RIBBLE VALLEY
BOROUGH COUNCIL

320111015P

From: Louise Blatchford
Sent: 07 December 2011 09:14
To: 'neil andrews'
Cc: Lesley Lund
Subject: Planning application - Hodder House, Chipping Road, Chaigley

RE: Alterations and extension to existing house
AT: Hodder House, Chipping Road, Chaigley

existing plans
and elevations

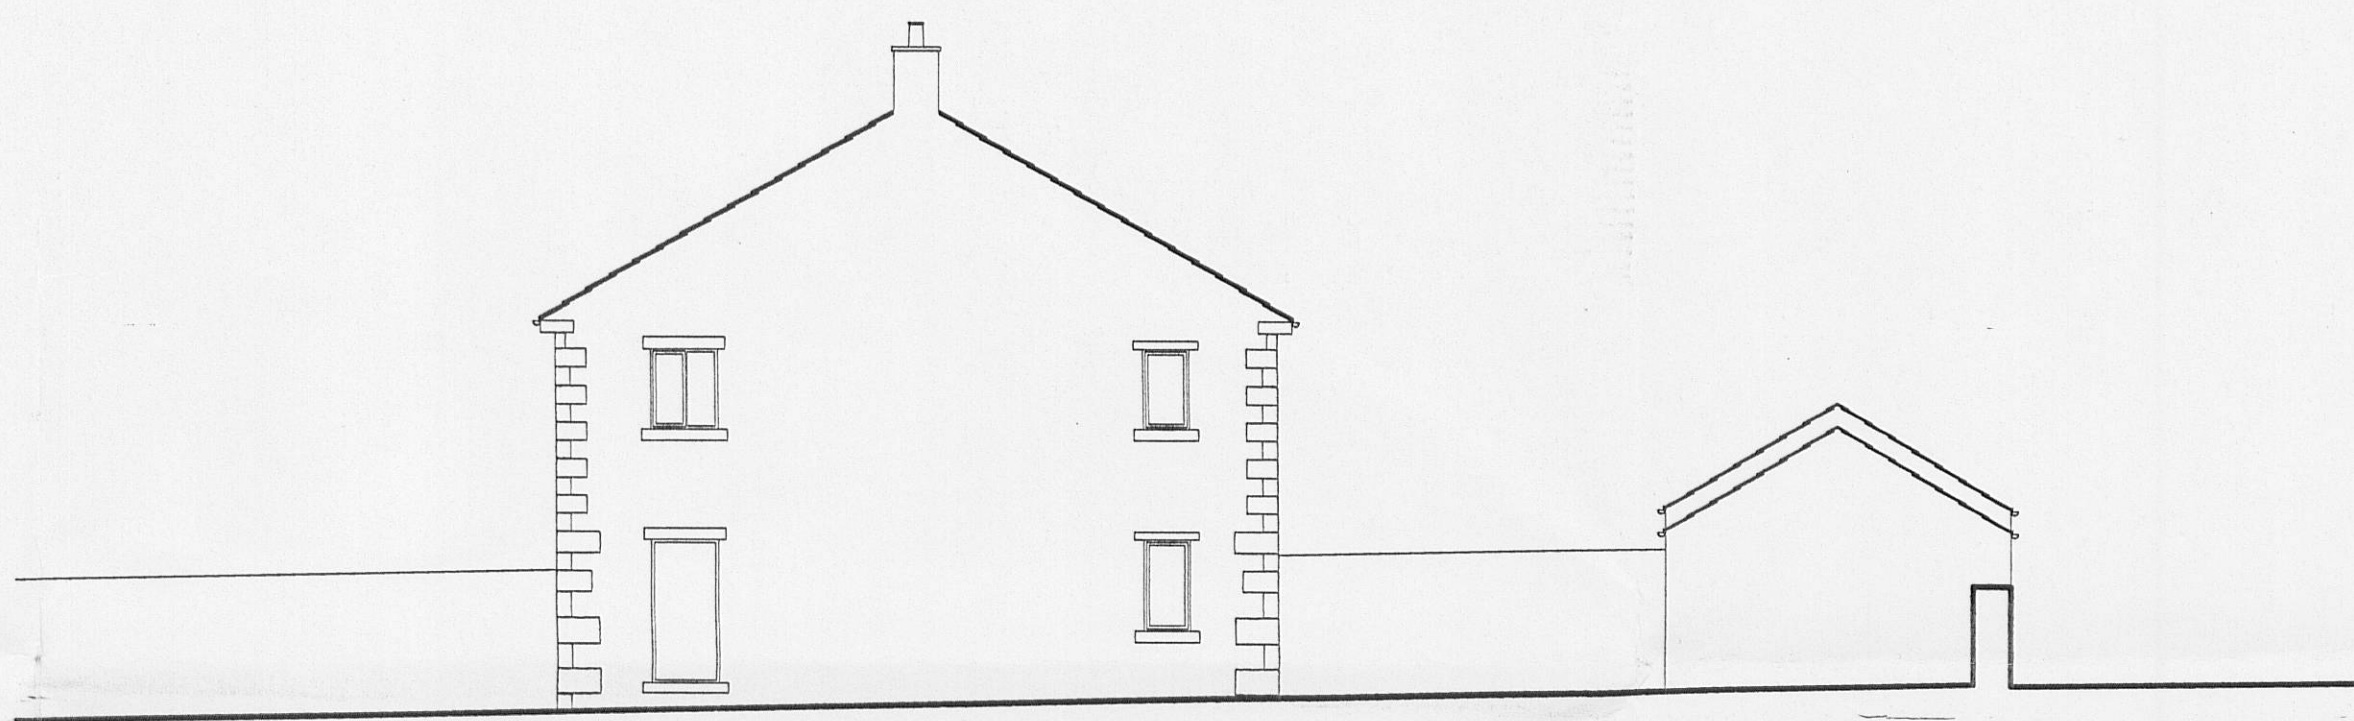
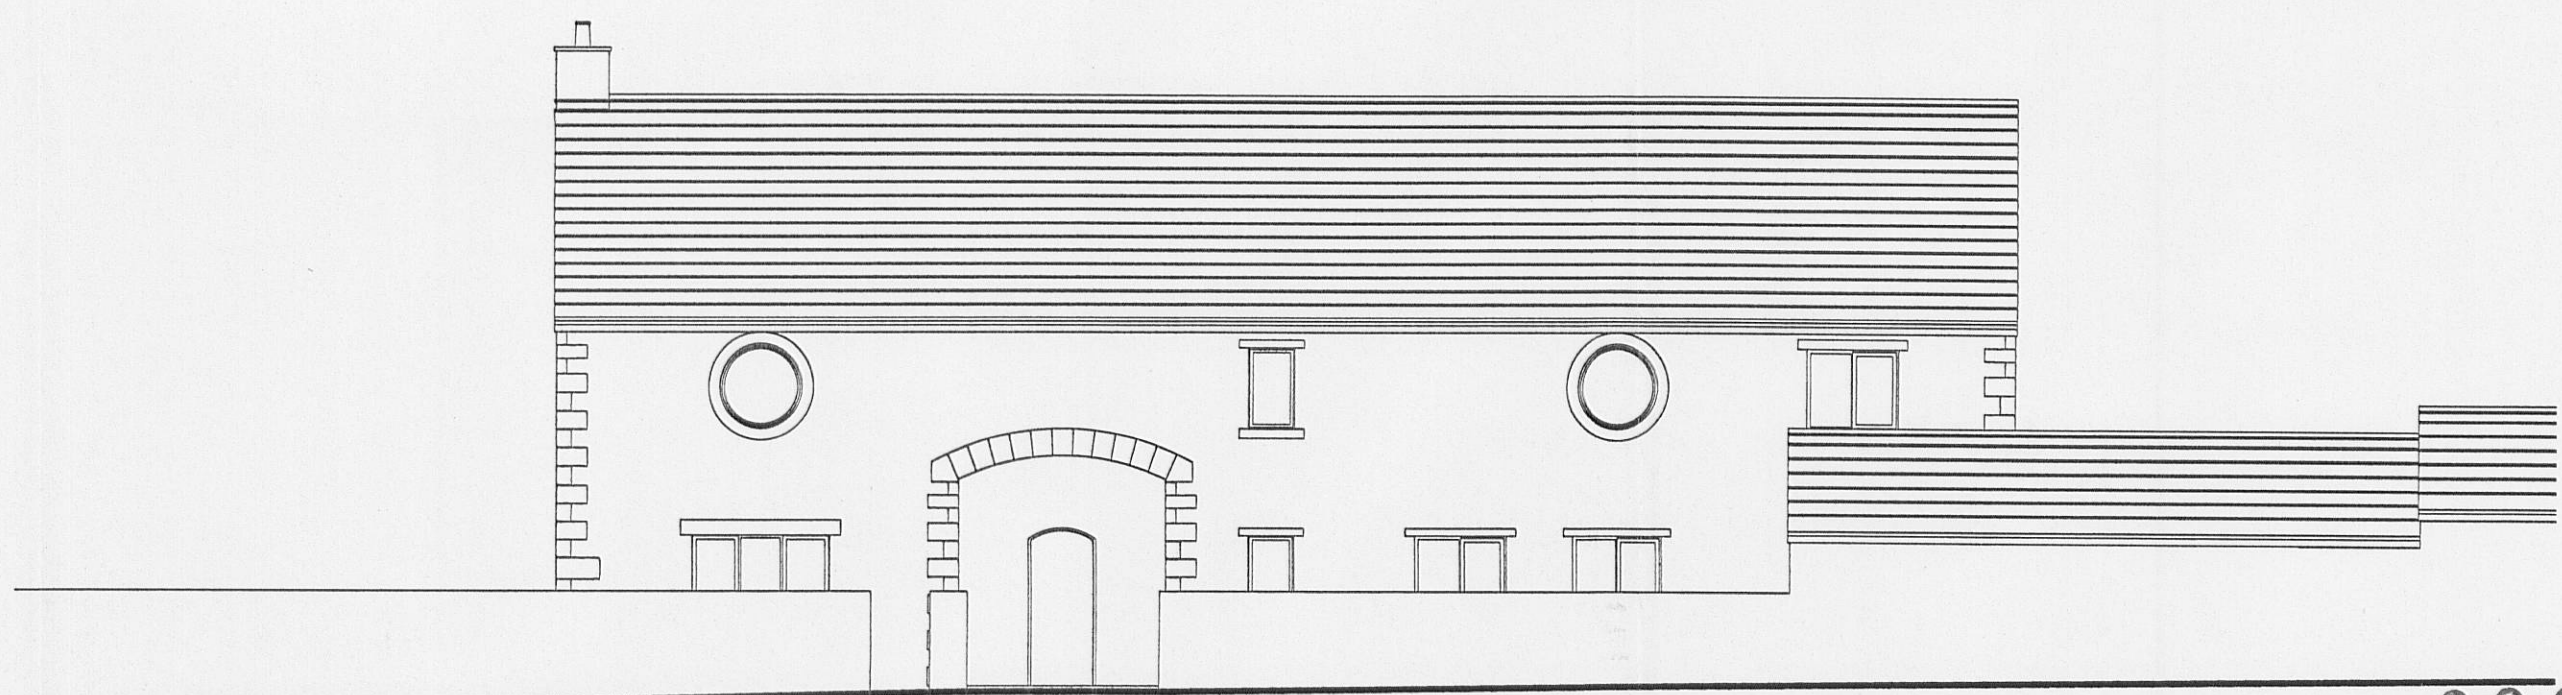
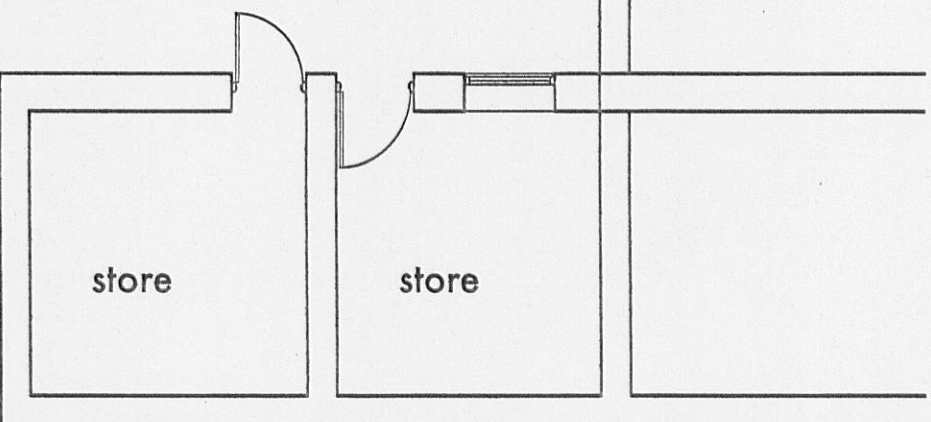
- The existing elevations only show the outline of the existing outbuilding which is to be renovated. The planning officer will need to see the elevations of the existing outbuilding so that they are able to make a comparison between the existing and the proposal. Please could you provide an additional plan to show this.

proposed plans
and elevations

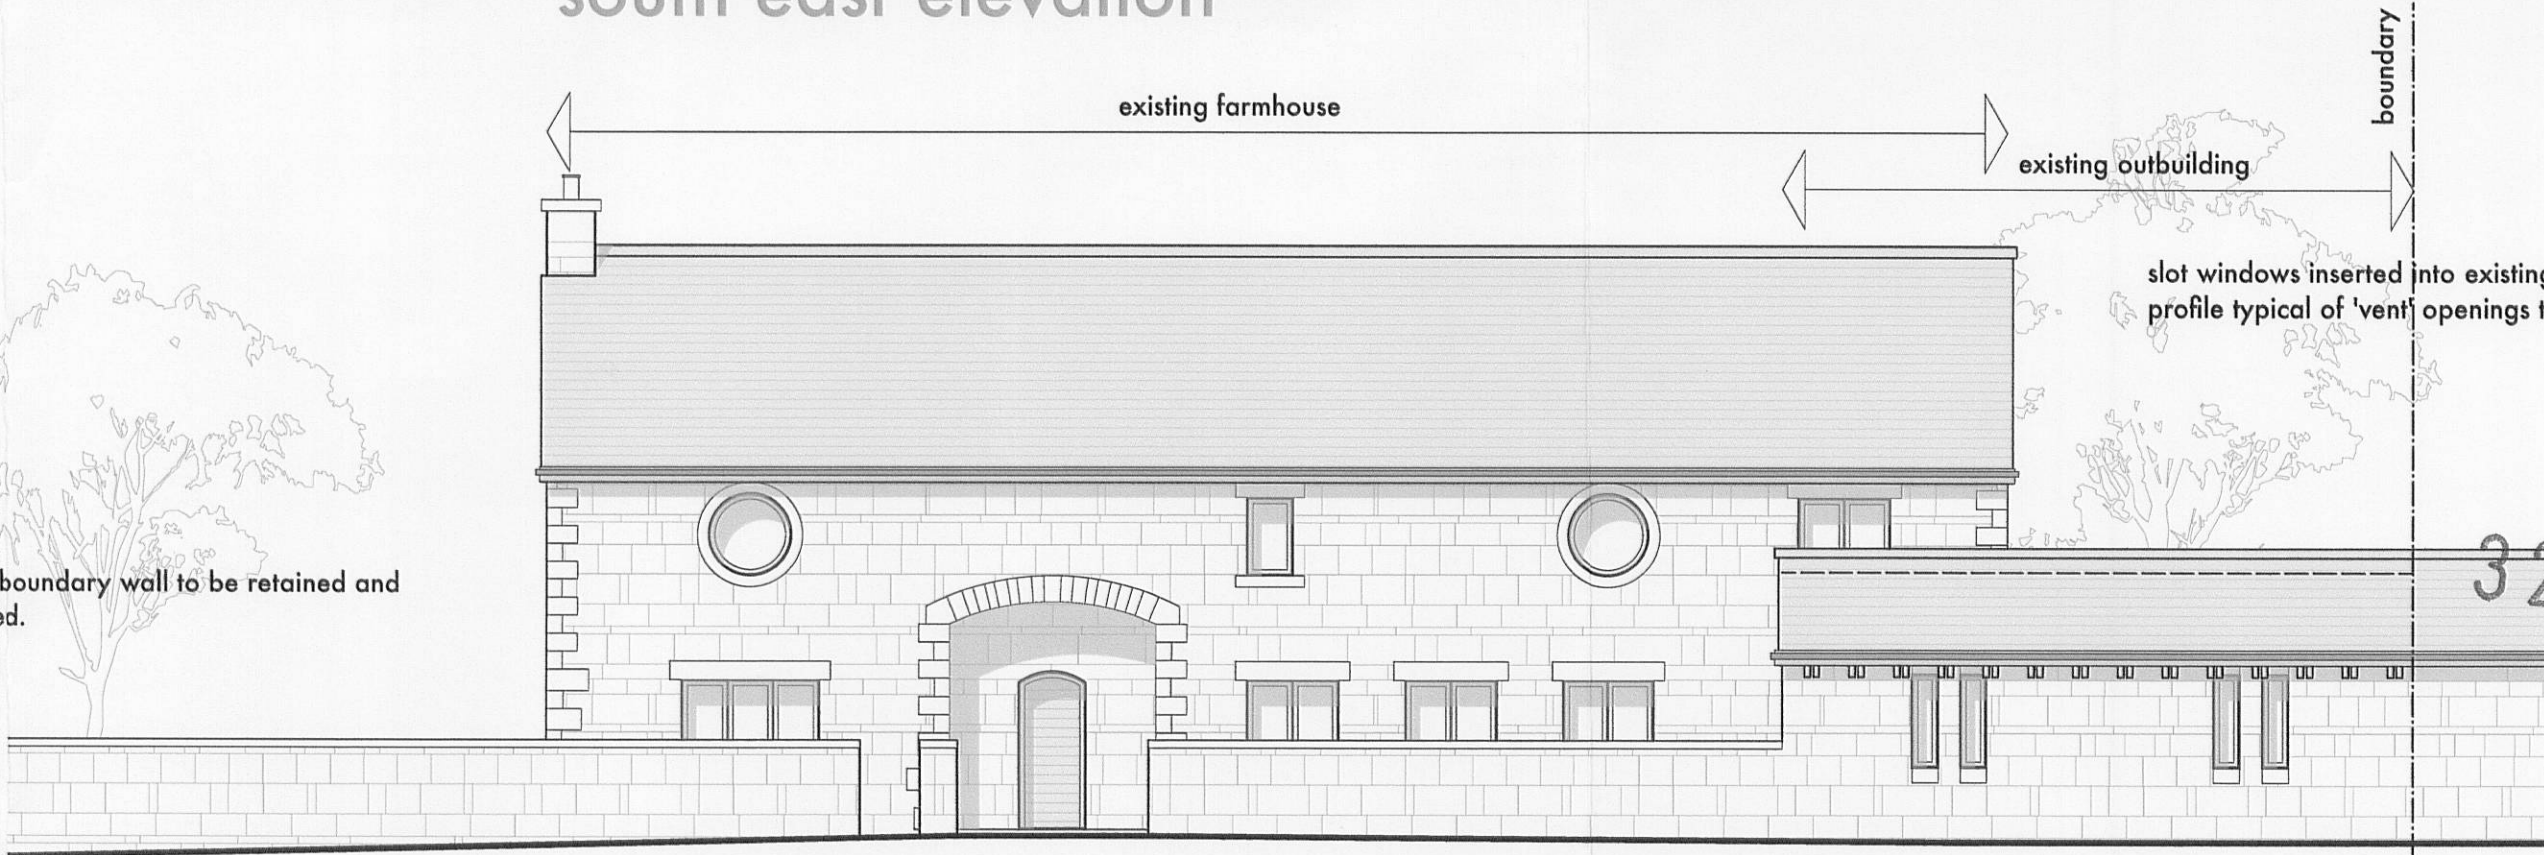
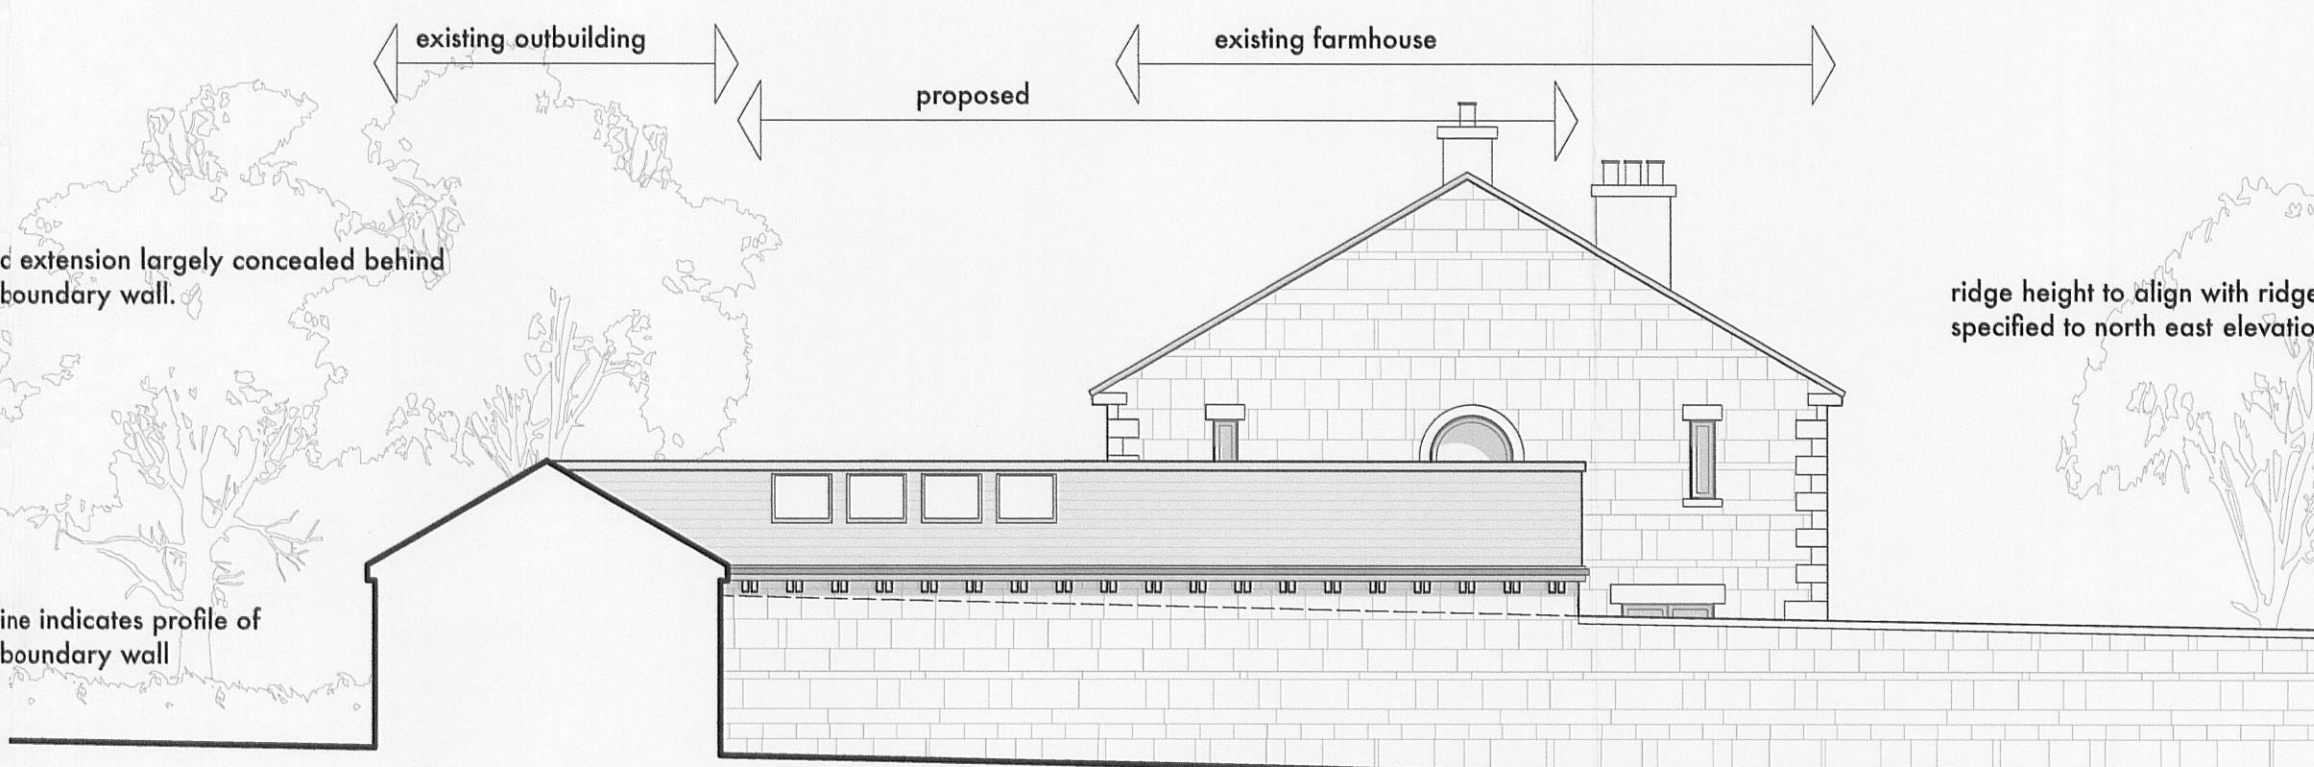
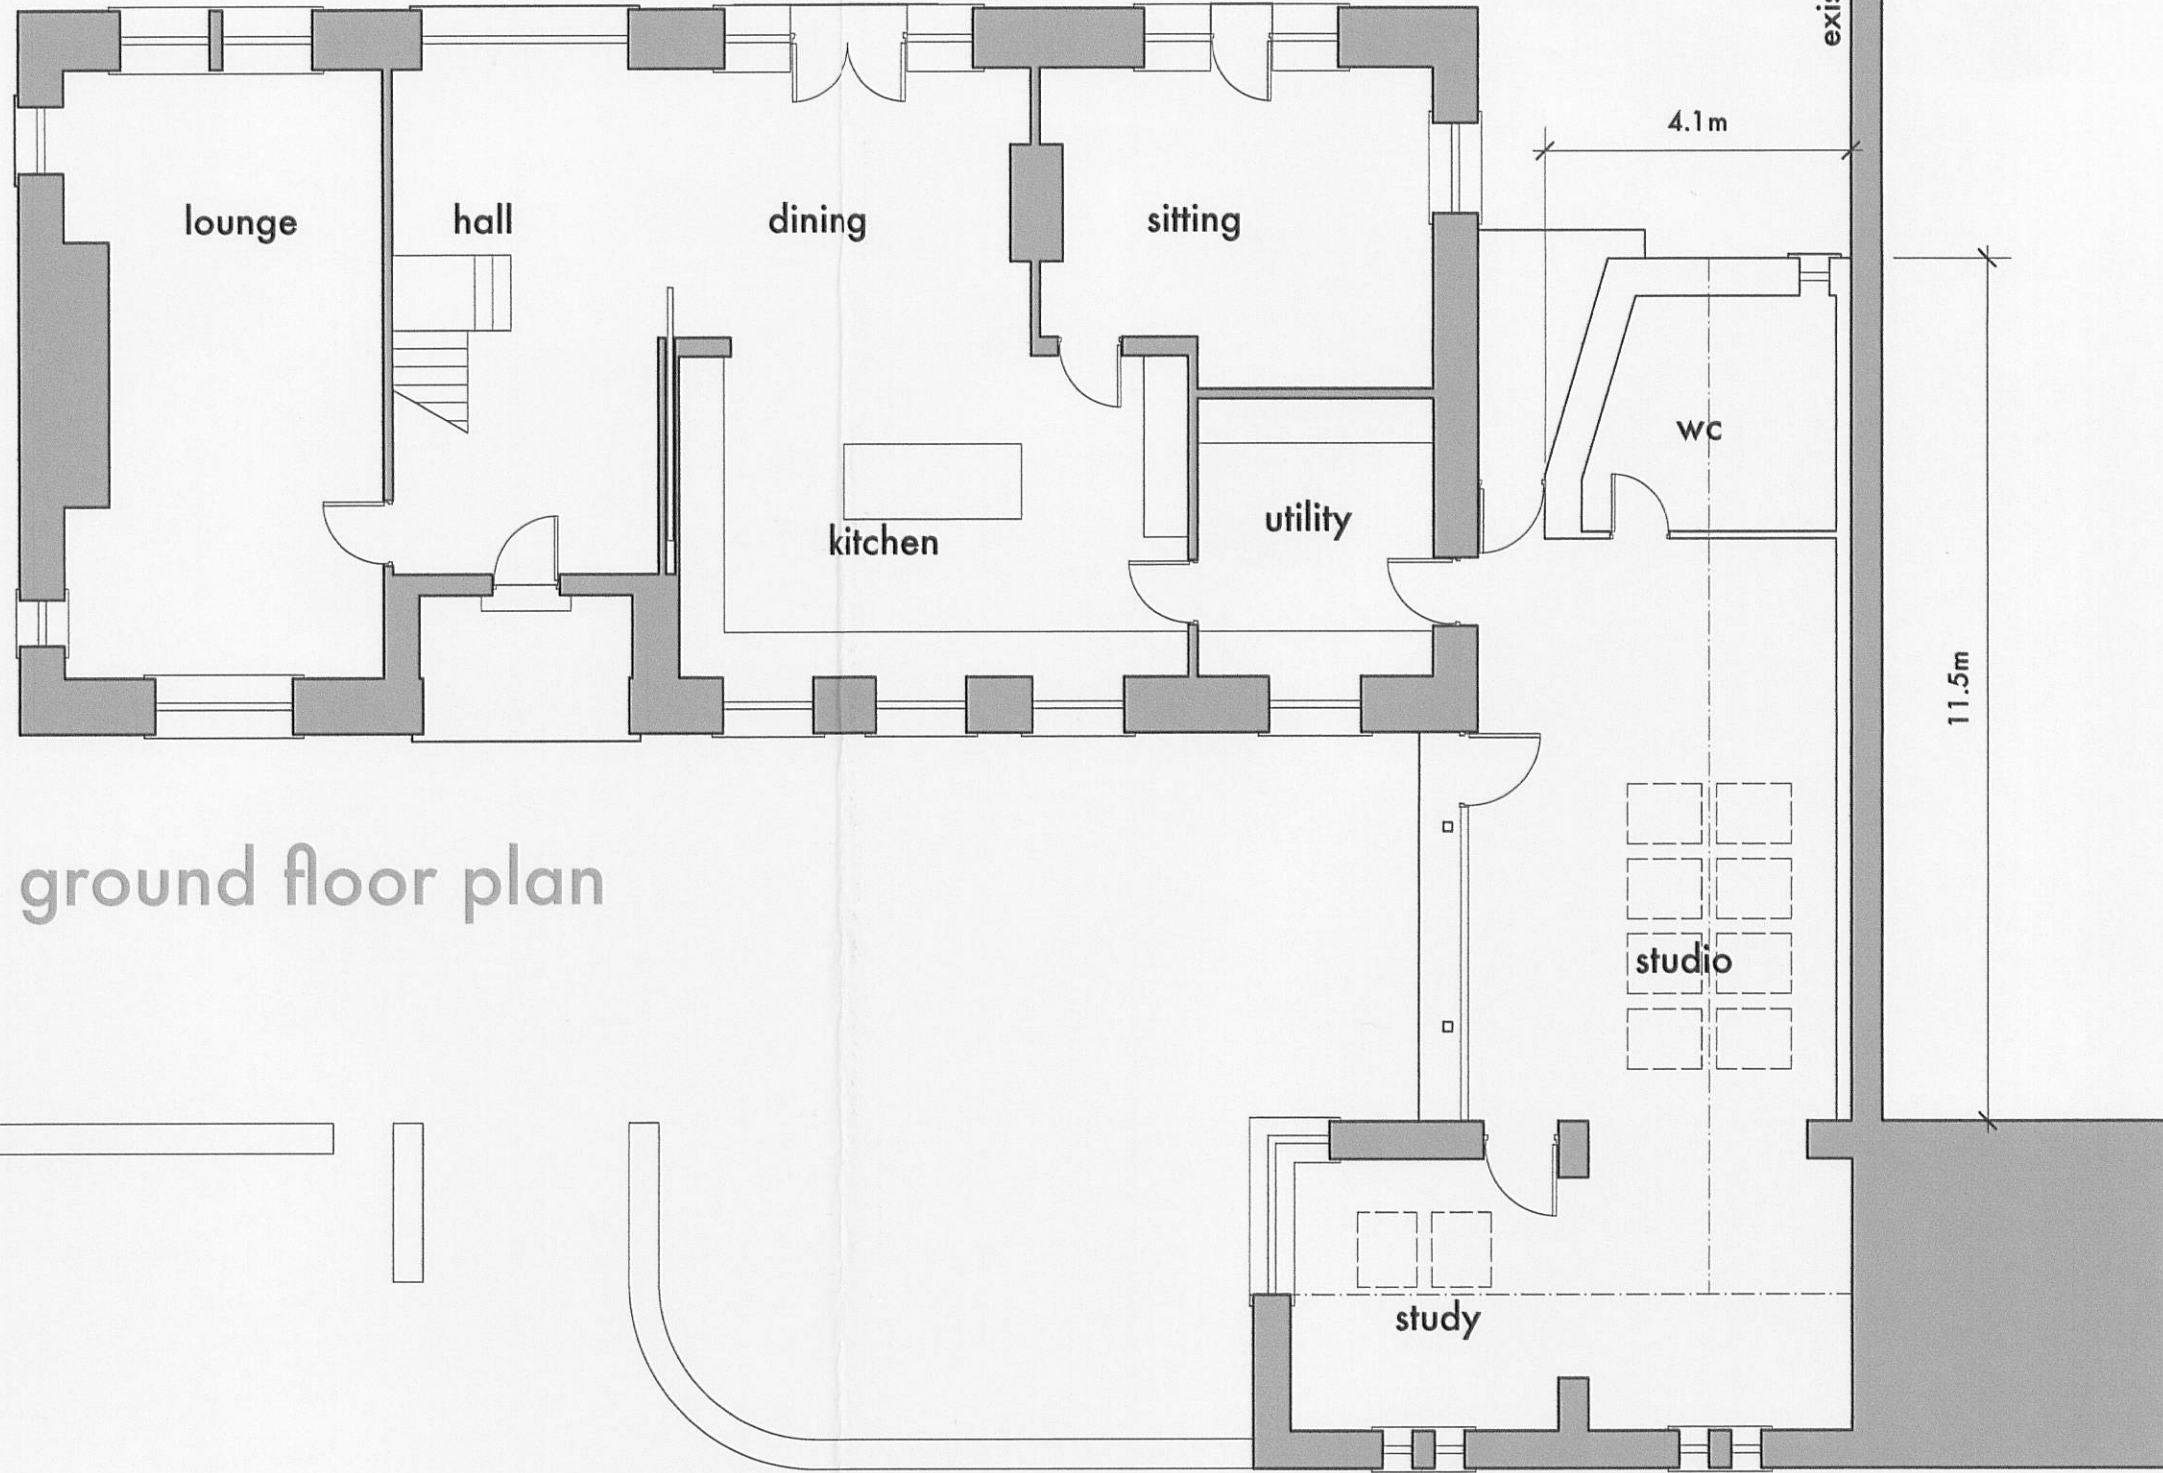
- Finally, we appreciate that the plans state that the proposed extension will match the ridge height of the adjacent outbuilding and the width will be as existing but we do require all proposals to be annotated with dimensions. Please would you mind adding the overall external height and width dimensions of the proposed extension to the plans - this isn't just for our benefit, it assists members of the public and parish councils when they are viewing the plans.
